From: THERESA WOODWARD [REDACTED]
Sent: 18 May 2022 09:33
To: Kathryn Welch <Kathryn.Welch@arun.gov.uk>
Subject: Re: West House Planning application EP/35/22/HH Objection

I am writing to object to planning application EP/35/22/HH

E ELEV

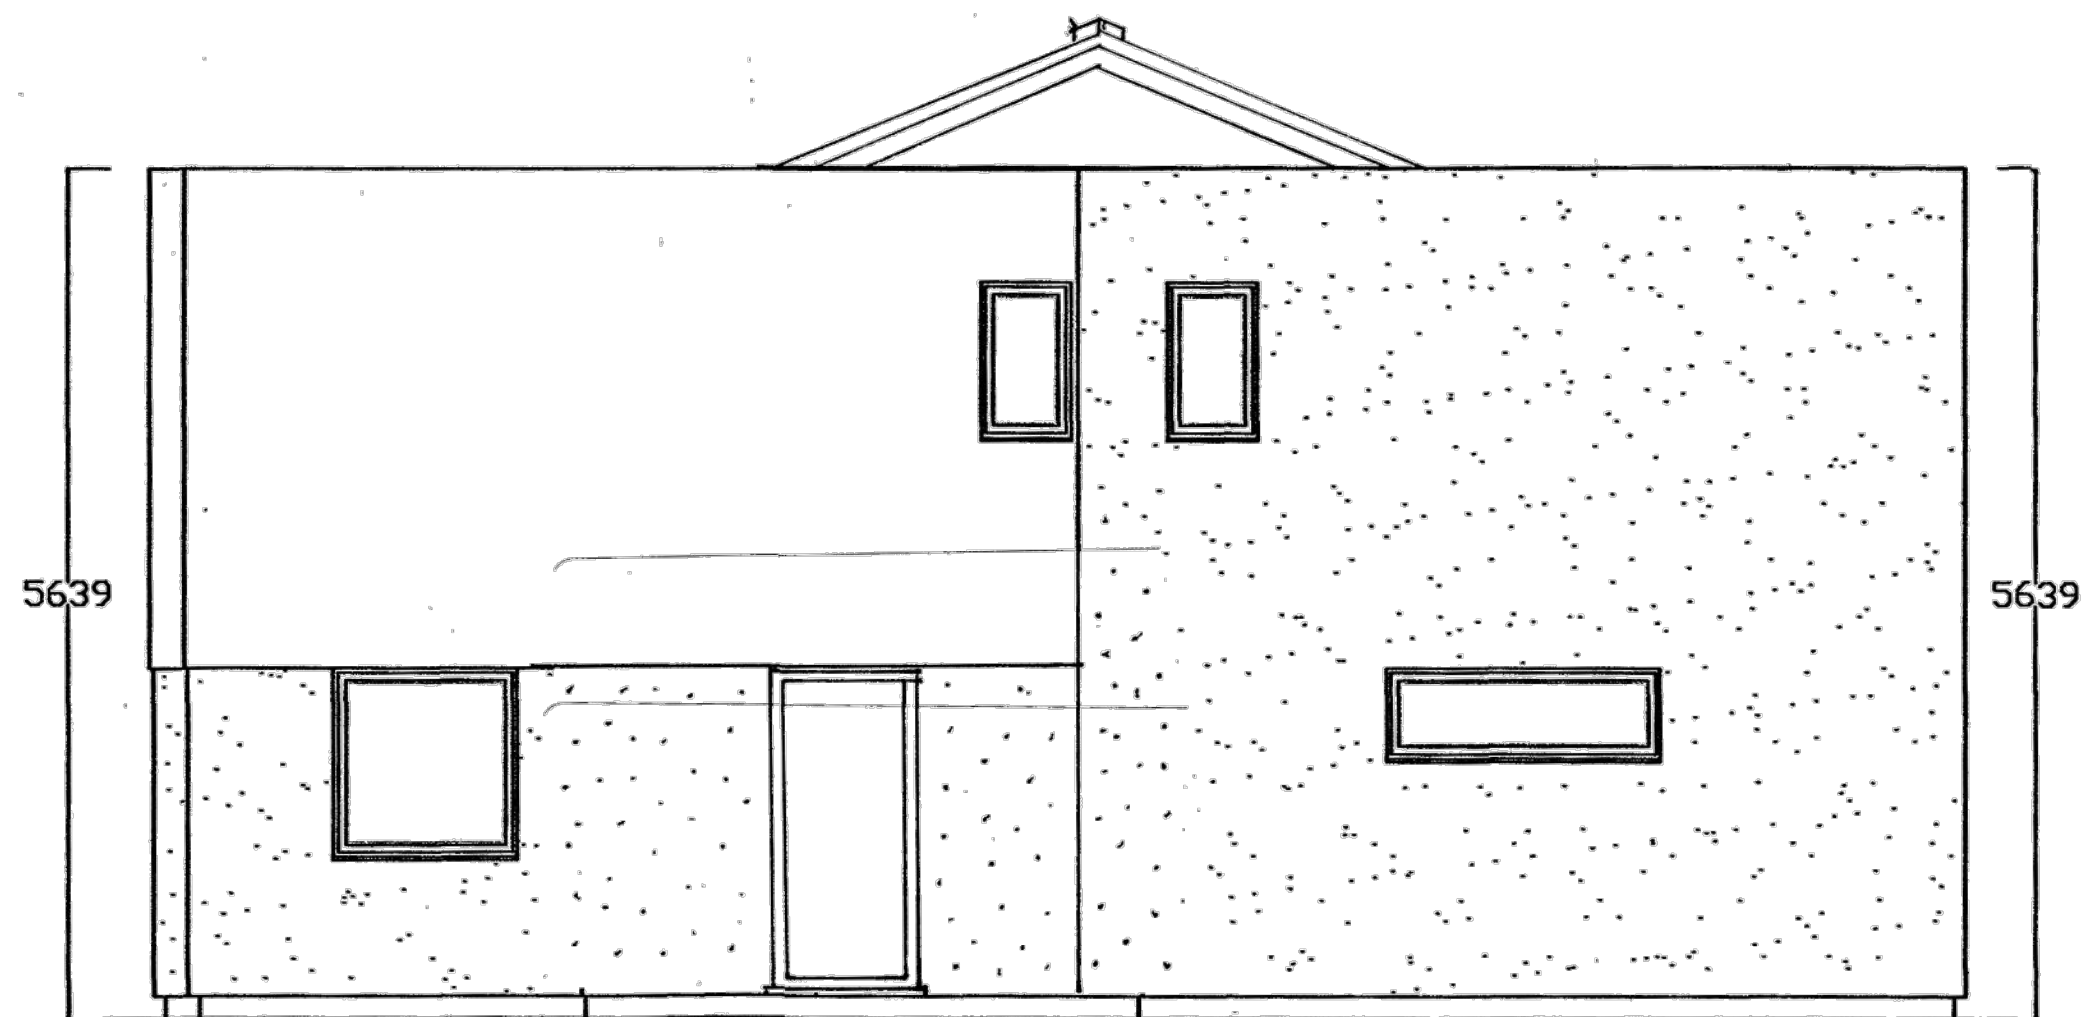
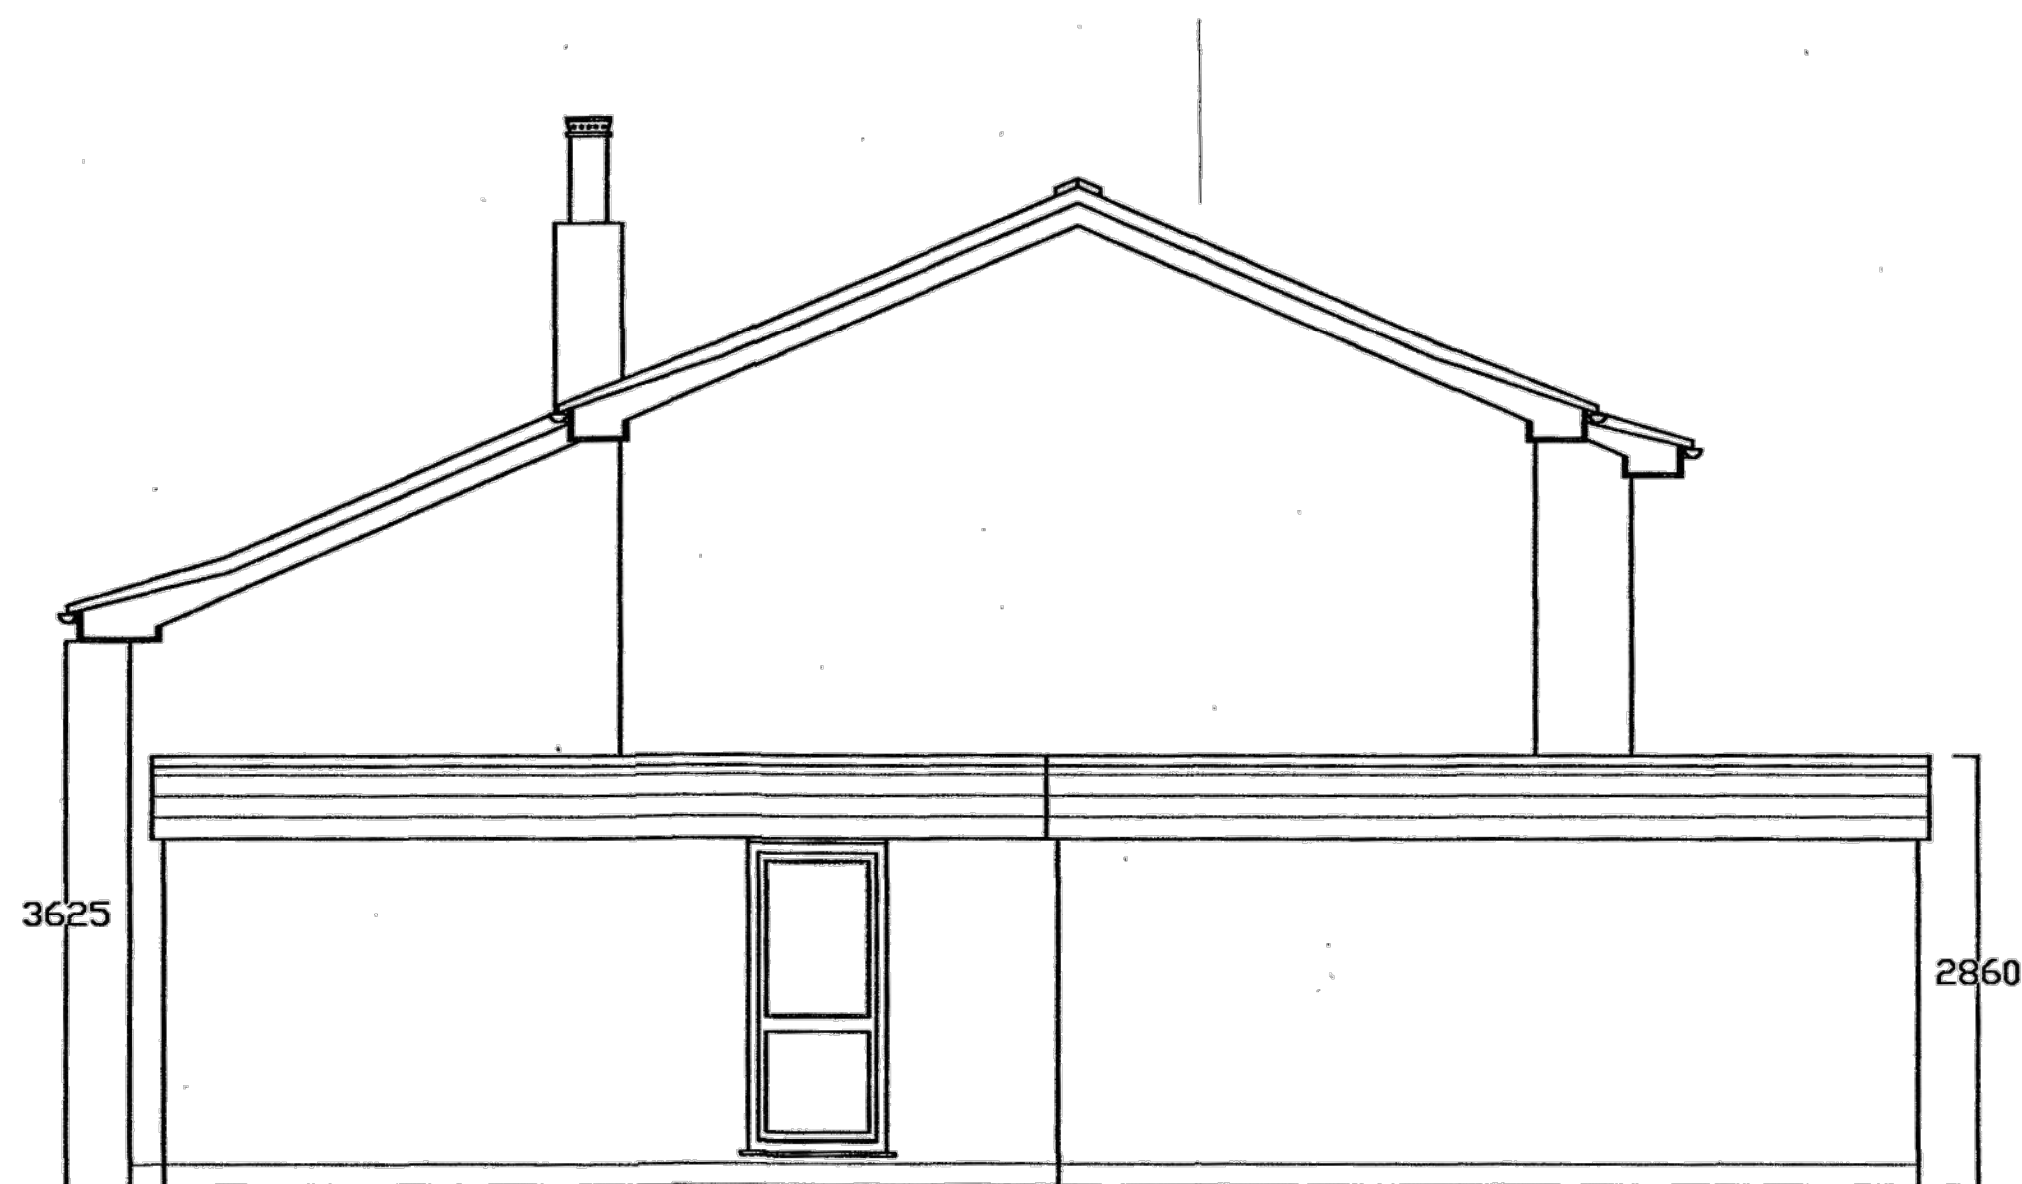
70 deg rule for the side extension between West House and Whitecroft.
